2nd August 2017

Mixed use development, A259 New Road, Rustington - Ref: A/11/17/OUT

P McLaughlin
for The Redwood Partnership
Encs.

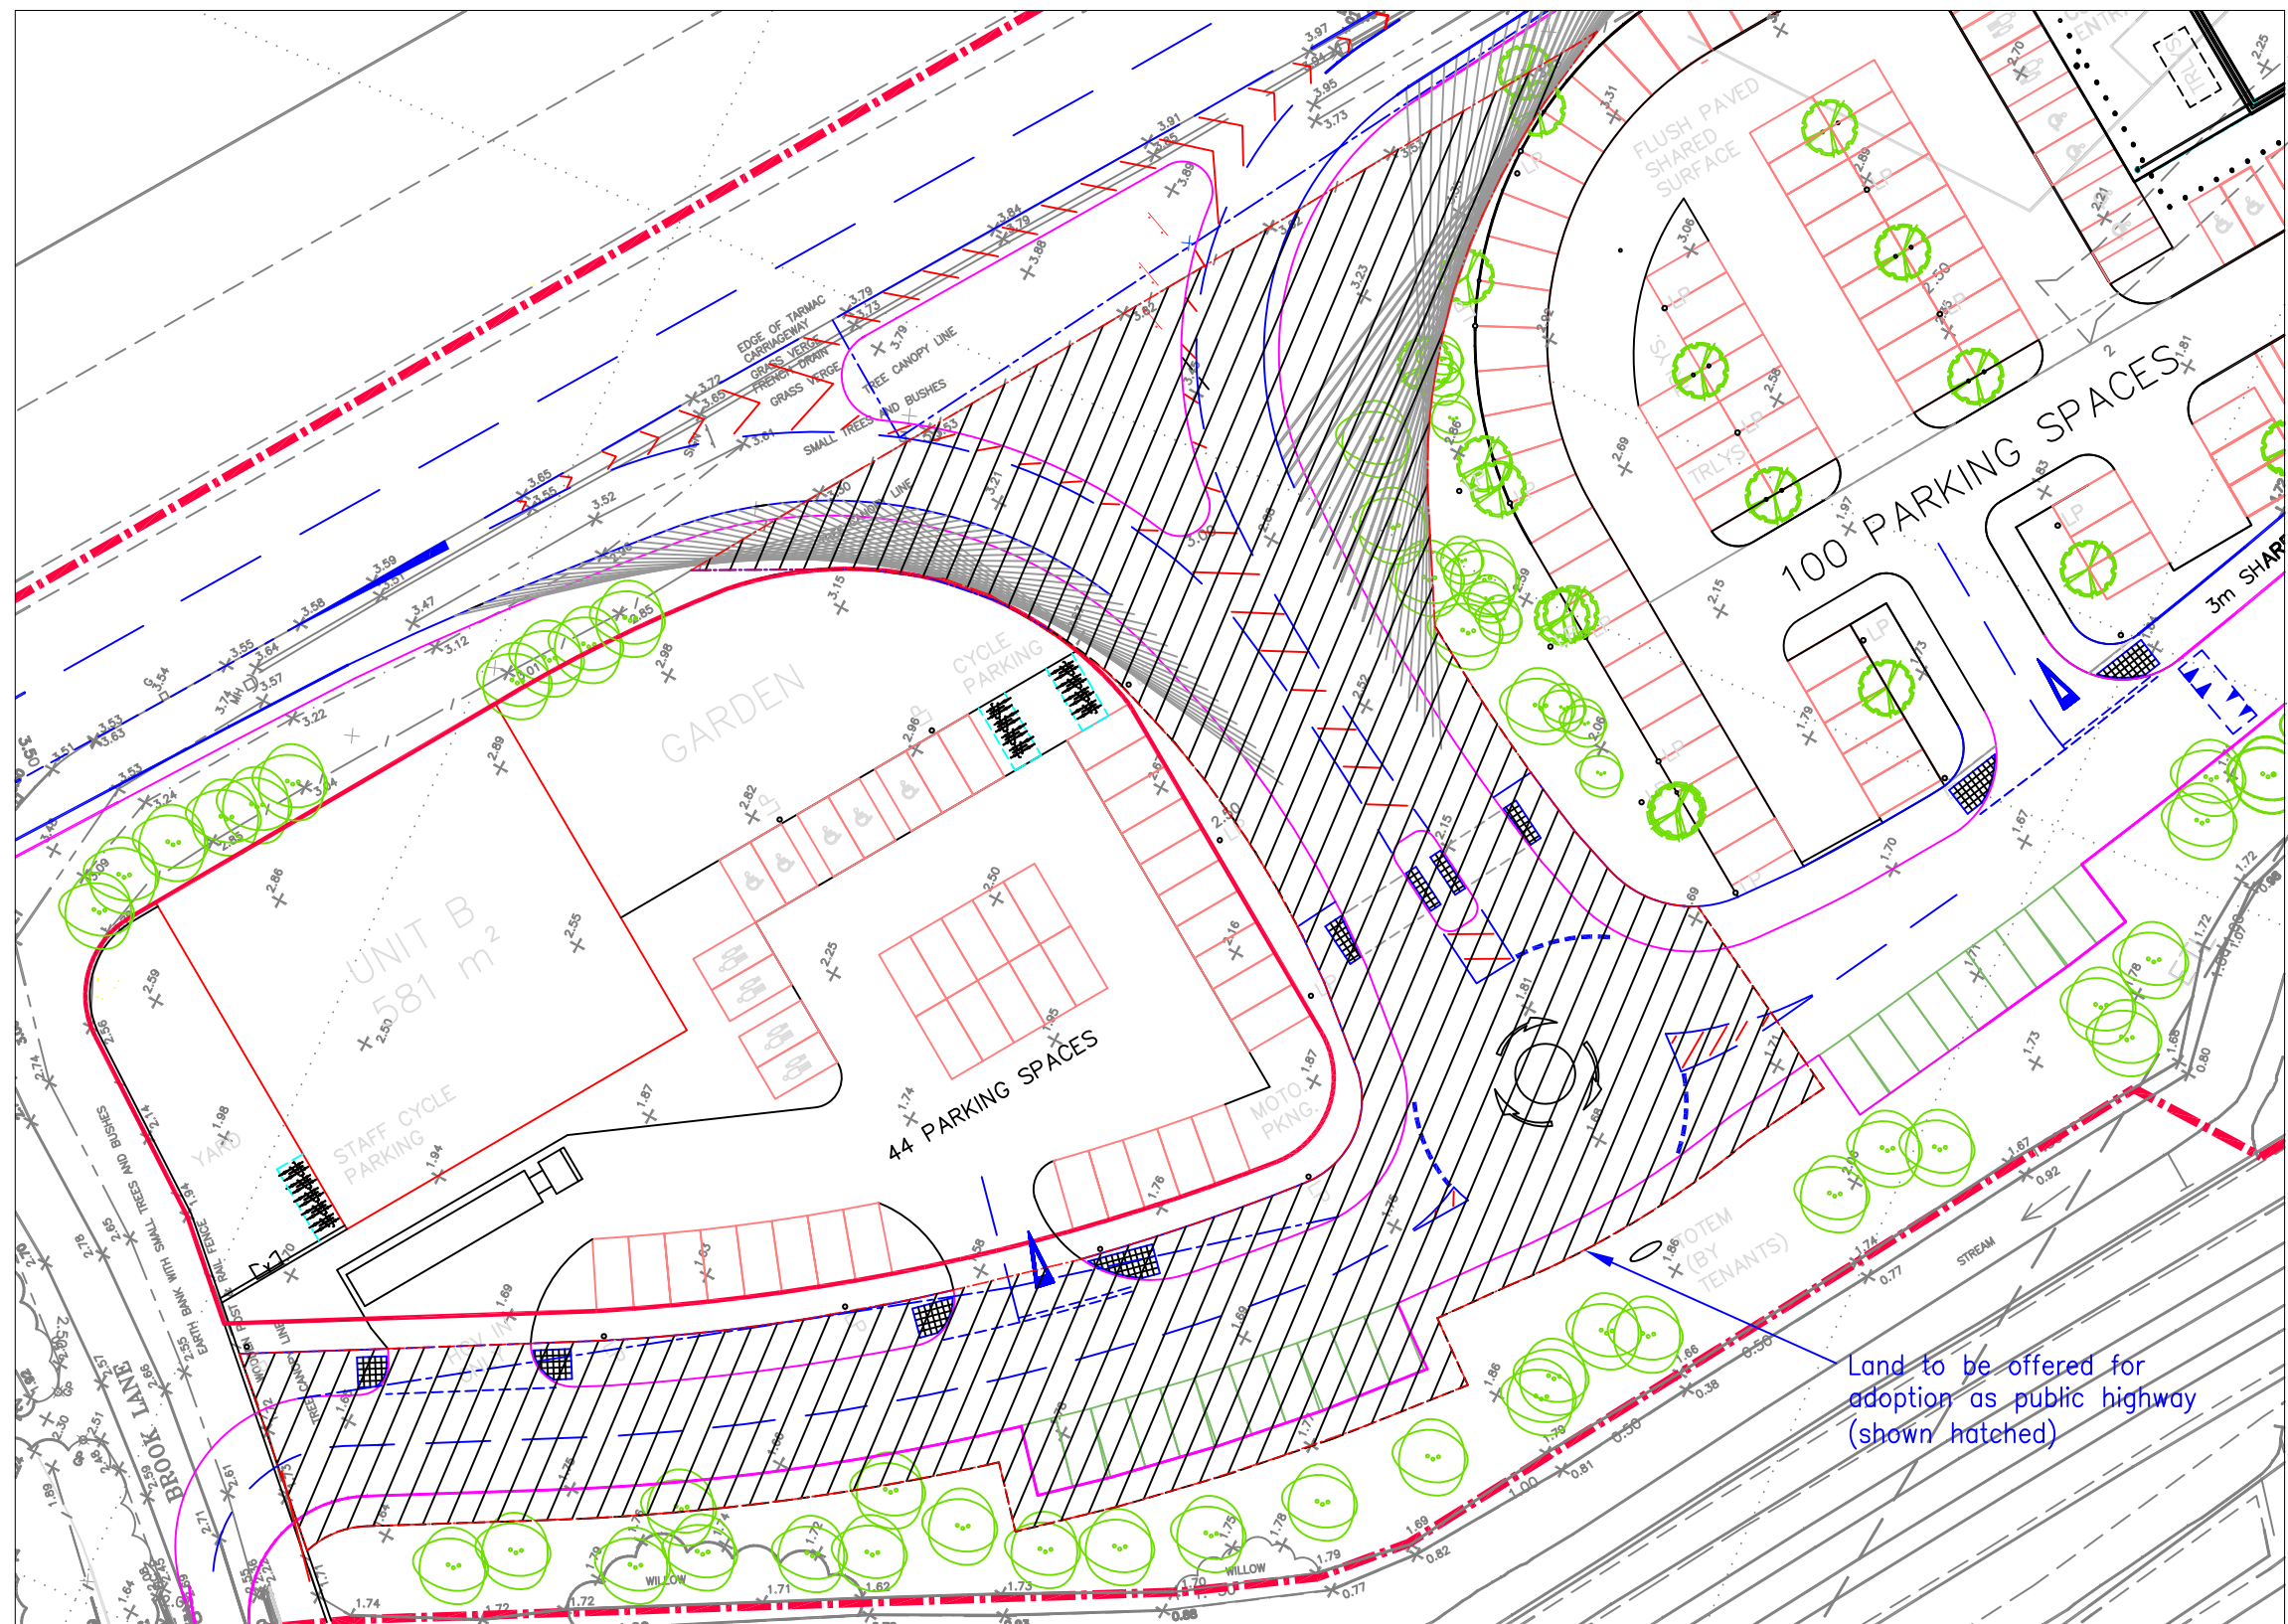
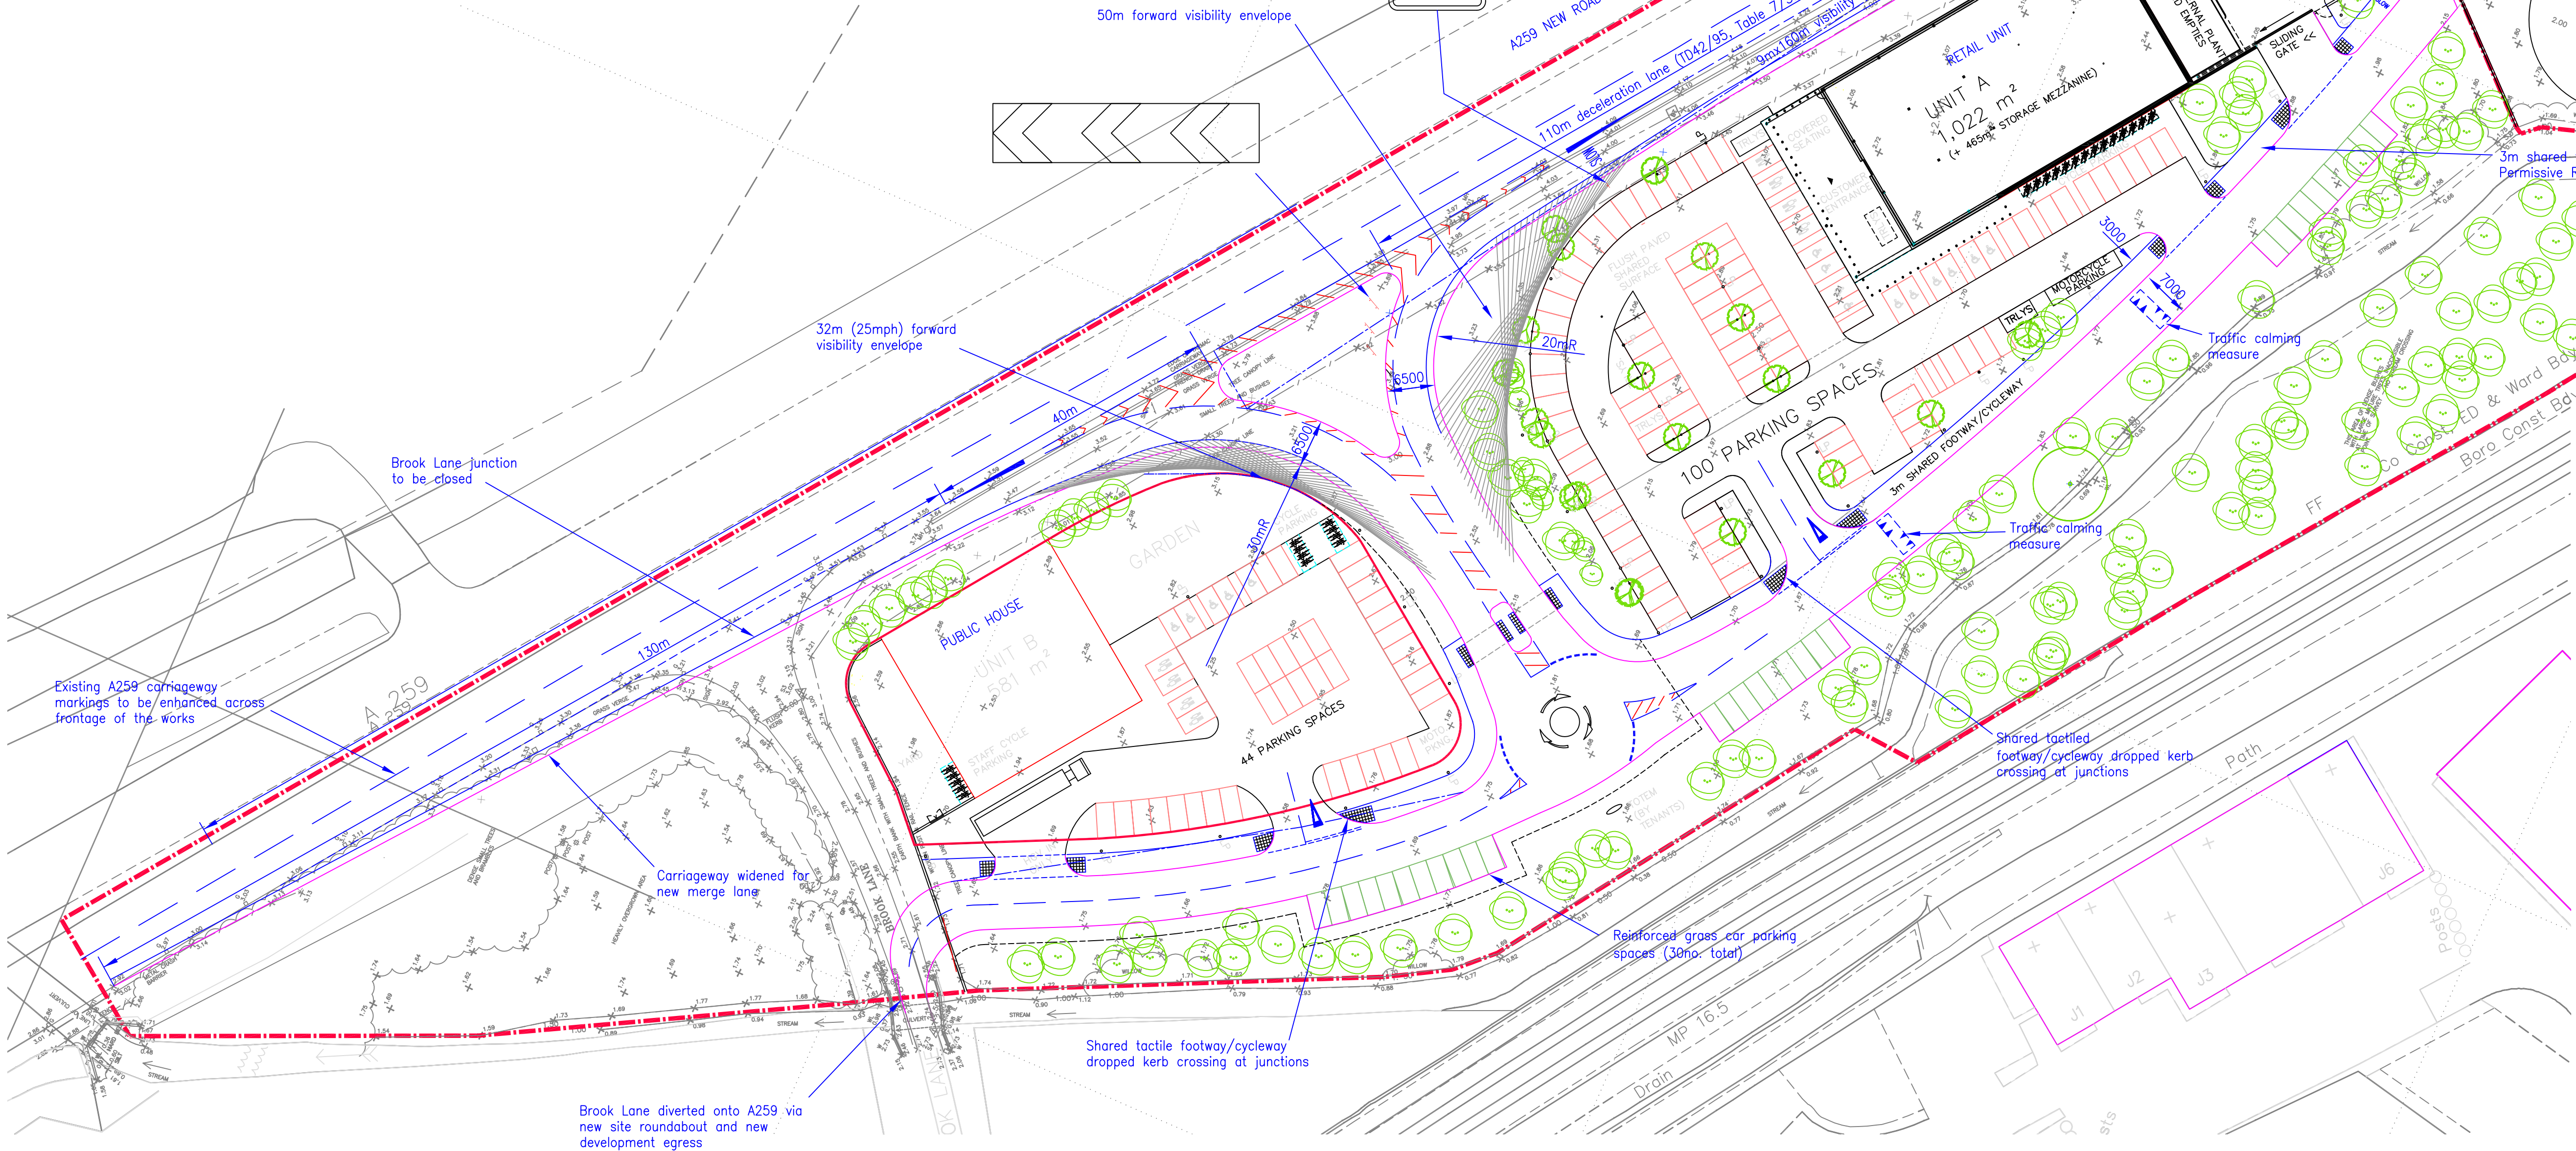
In order for WSCC and others to assess this properly, REDW-3167-120A, REDW-3167-131A, and Site Layout plan 1117-P-11G should be amended to correctly reflect the adjoining As Built scheme.'

The Applicant has advised us that a footpath/cyclepath link only between the two sites may be considered in the future; however the access proposals for this application are not dependent upon any such link. I enclose amended plans **Drawing No REDW-3167-120-B** and **Drawing No REDW-3167-131-B** showing a correction to the Manor Retail Park layout to accord with their 'as-built' layout. This has no effect on the development proposals.

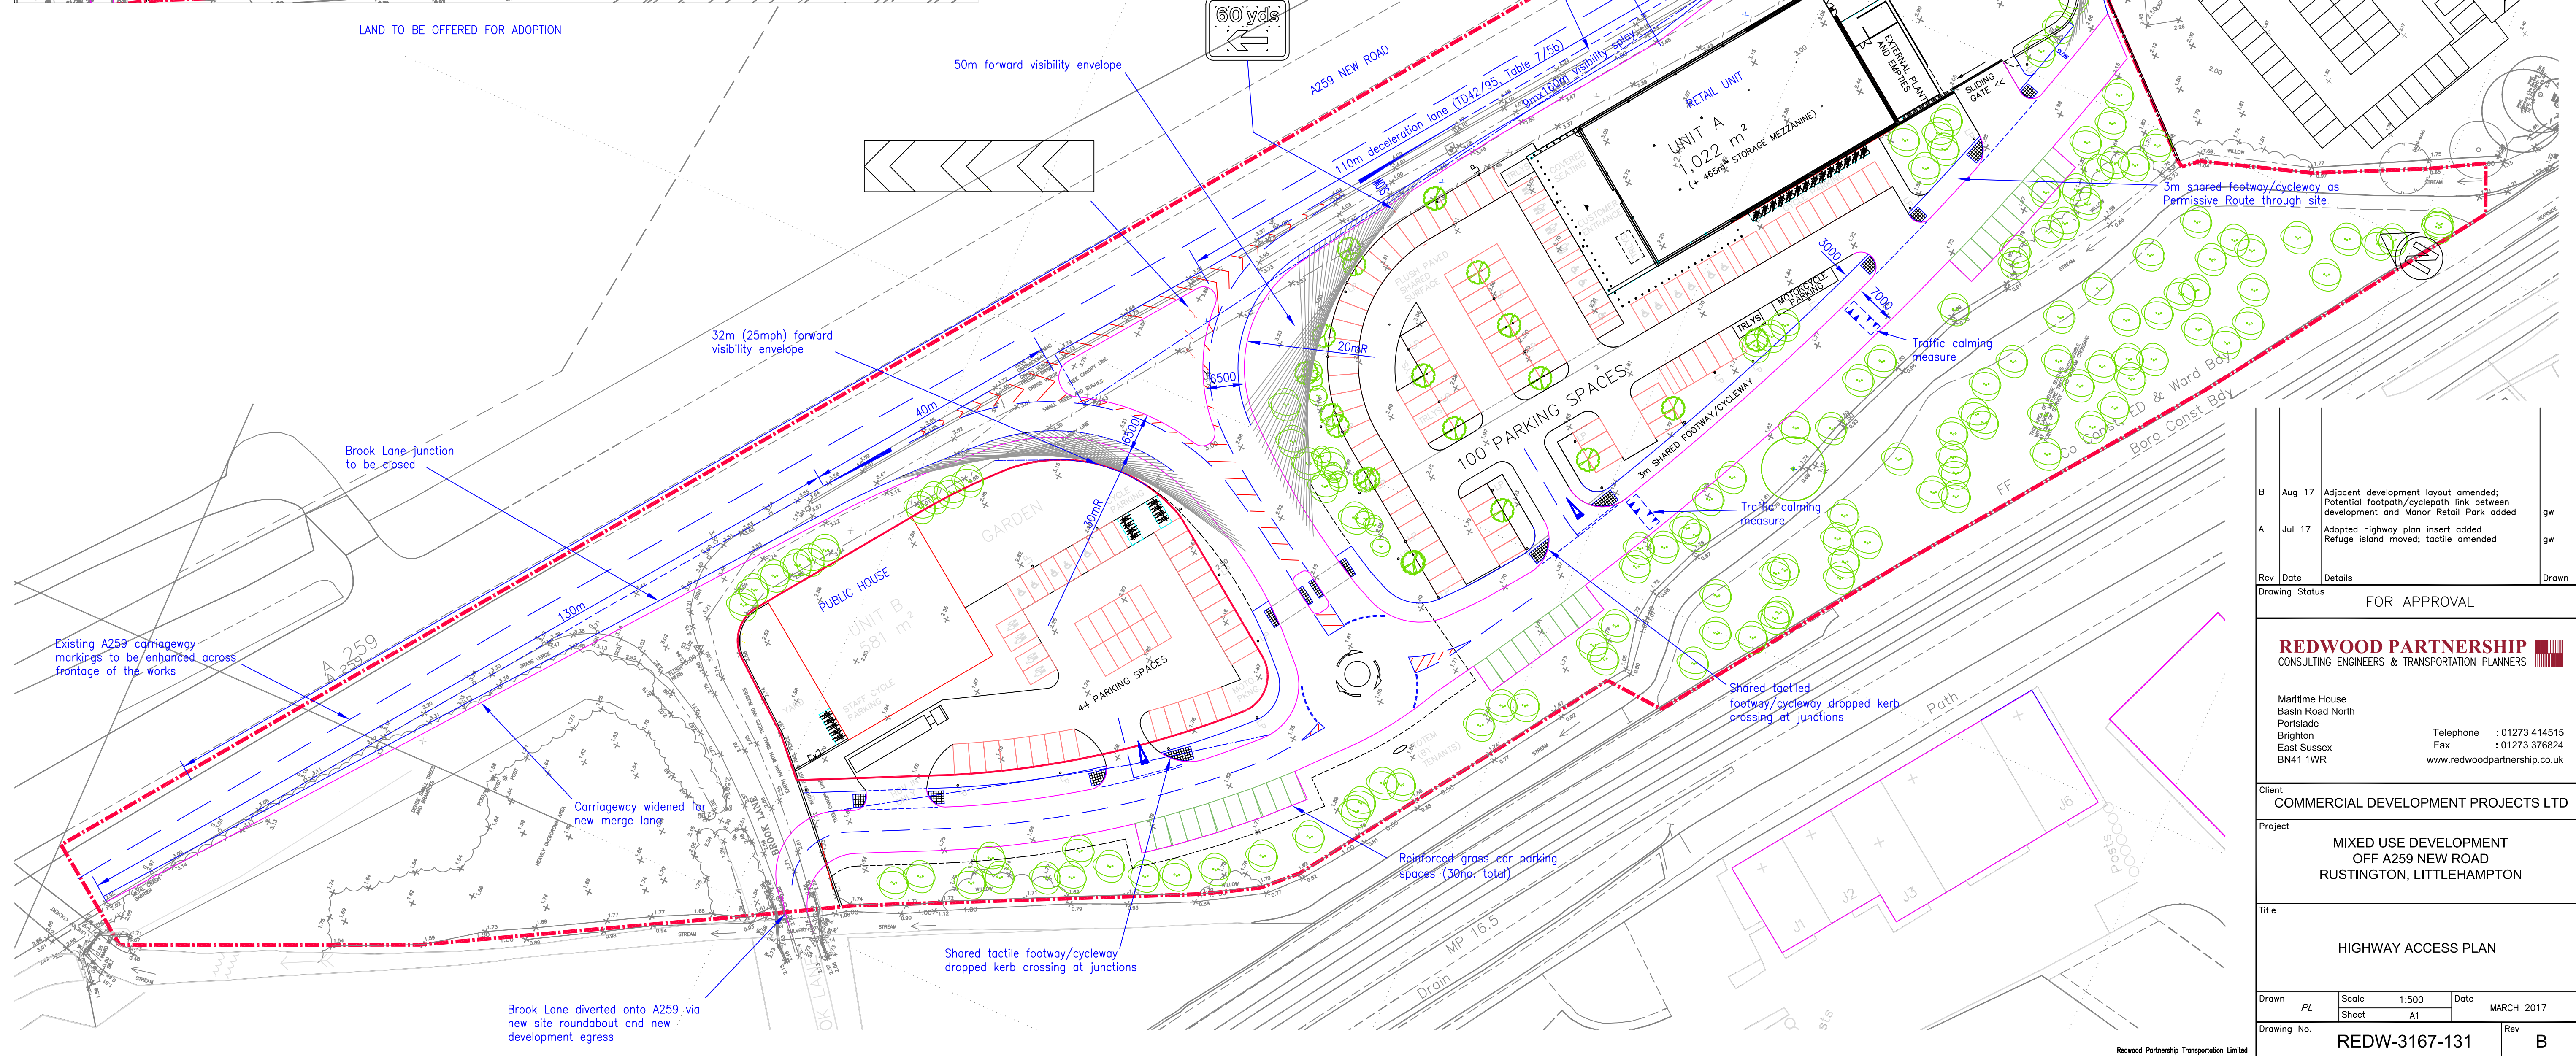
- The applicant is still not showing the correct As Built development to the east of the site. This is misleading and incorrectly implies that the two retail schemes could be linked by pedestrians and vehicles in the future. The applicant has legal rights to access its application land through Manor Retail Park which was designed and constructed to facilitate this future link. As proposed the applicants development layout permanently precludes this, as demonstrated in the attached hybrid plan.*

- This suggestion cannot be fulfilled and is entirely hypothetical. There has been no correspondence or discussions with the applicant regarding the potential closure of Brook Lane which I confirm we own, and we do not agree to its closure.*

In our opinion, to provide a safe access from Brook Lane onto the A259 New Road for any new development an upgraded junction with appropriate acceleration and deceleration lanes will be required. As such the existing Brook Lane simple priority junction onto the A259 will need to be closed and a fully compliant junction constructed as shown on our **Drawing No REDW-3167-131-B**

which the Applicant has confirmed can be used by the housing scheme. The relevant point is that the A/11/17/OUT access location has now been approved by WSCC as an acceptable access proposal for the development

The closure of Brook Lane will require the approval of West Sussex County Council who will ensure that users of Brook Lane still have a legal route to the A259 and access to the public highway which they currently enjoy. To this end, we are working with WSCC to agree the principle of the Highway Authority adopting the site access, mini roundabout and public house access road as far as the western boundary so that the Brook Lane access can be easily diverted through an adopted route within the A/11/17/OUT application site.
